Application No: AB/114/20/PD

Site Address: Riverside House 2 Fitzalan Road Arundel BN18 9JS

Description of works: Notification for Prior Approval under Schedule 2 Part 1 Class AA for a additional 2 storeys on existing dwelling house.

Thank you for your internet representation made on 30th November 2020 which has been recorded as an objection with the comments as follows:

Drawing Title:
PROPOSED ELEVATIONS

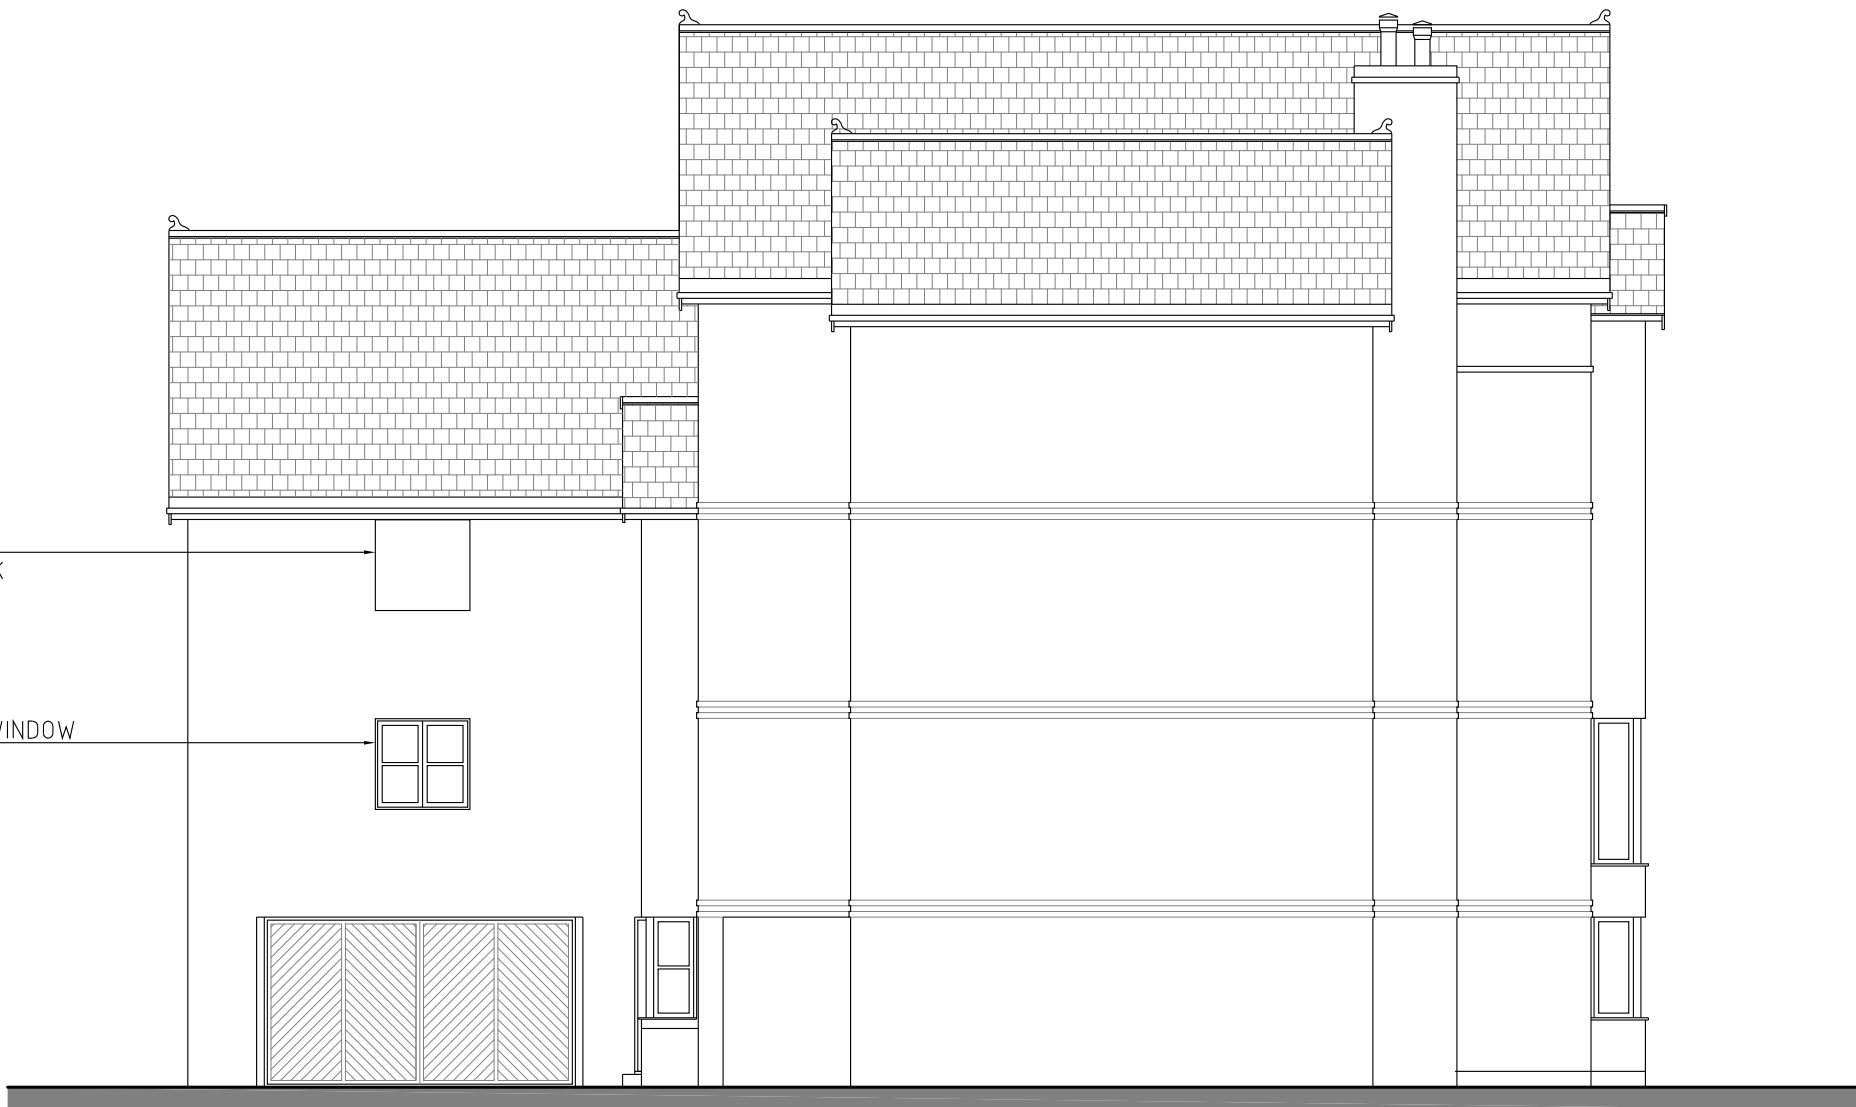
The proposed two storey extension by reason of its site coverage, bulk, height, proximity to the site boundaries and location close to the Arundel Conservation Area would result in a prominent and obtrusive dwelling which would adversely affect the visual amenities and the character of the area and would not preserve or enhance the setting of the Conservation Area. It would therefore be contrary to policies AREA2, GEN7 and DEV19 of the Arun District Local Plan and the National Planning Policy Framework.
